To: The Planning Inspectorate, 16th Dec 2025

Pollution and health risks fears from BESS Fire Emissions

Excerpts from EN010159-000515-7.11 (page 64) Outline Battery Safety Management Plan (clean).pdf)

*Figure C.2: Impacts from Unplanned Emissions at Eastern BESS Compound*

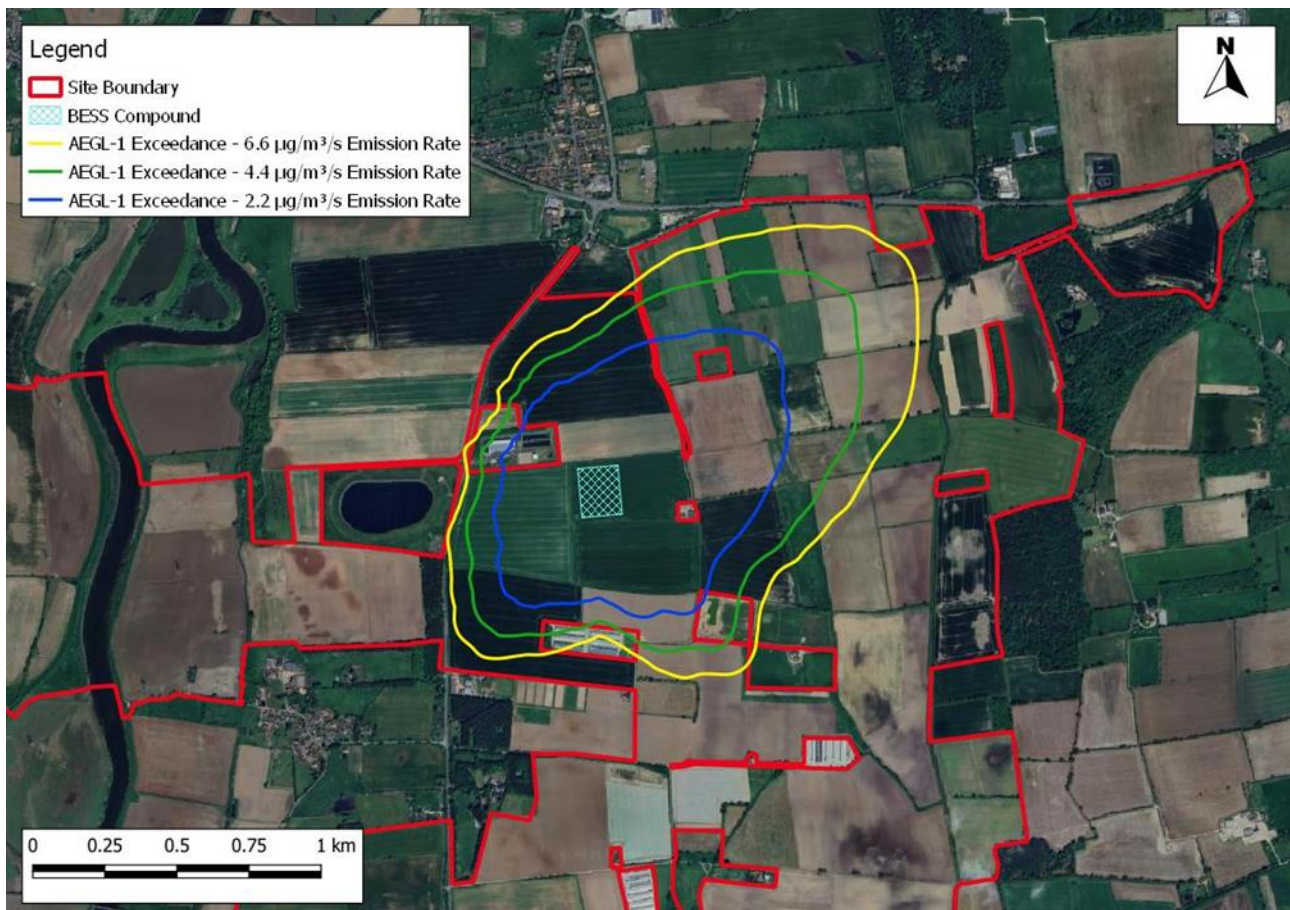
C.4.4.1. As illustrated in **Figure C.2**, at the eastern BESS site, in all emission rate scenarios there are no sensitive receptors located within the area where the assessment level may be exceeded in 90% of meteorological conditions. Thus, it can be concluded that a fire at the eastern BESS site would not result in any significant adverse health effects.

Our Note: Based on publicly available wind pattern analysis (see image below), the statement in the developer's document appears to be incorrect. Moreover, there are several sensitive receptors in this area, including three large poultry farms housing approximately 500,000 birds, a drinking water treatment plant supplying around 100,000 people, a 20-acre reservoir, numerous homes, the busy A1133 main road, and North Clifton village itself.

The wind/emissions/fallout diagram (above) is presented in a way that highlights the most ideal and least impactful wind direction. It is therefore disappointing that the developers have chosen to display the data under the most favourable conditions, as it is clear that if the wind were to blow from the east, the 20-acre North Clifton Reservoir would fall within the affected zones, and winds from the northeast would similarly place North Clifton itself within these zones. This selective presentation understates the potential risks under more realistic or less favourable wind conditions.
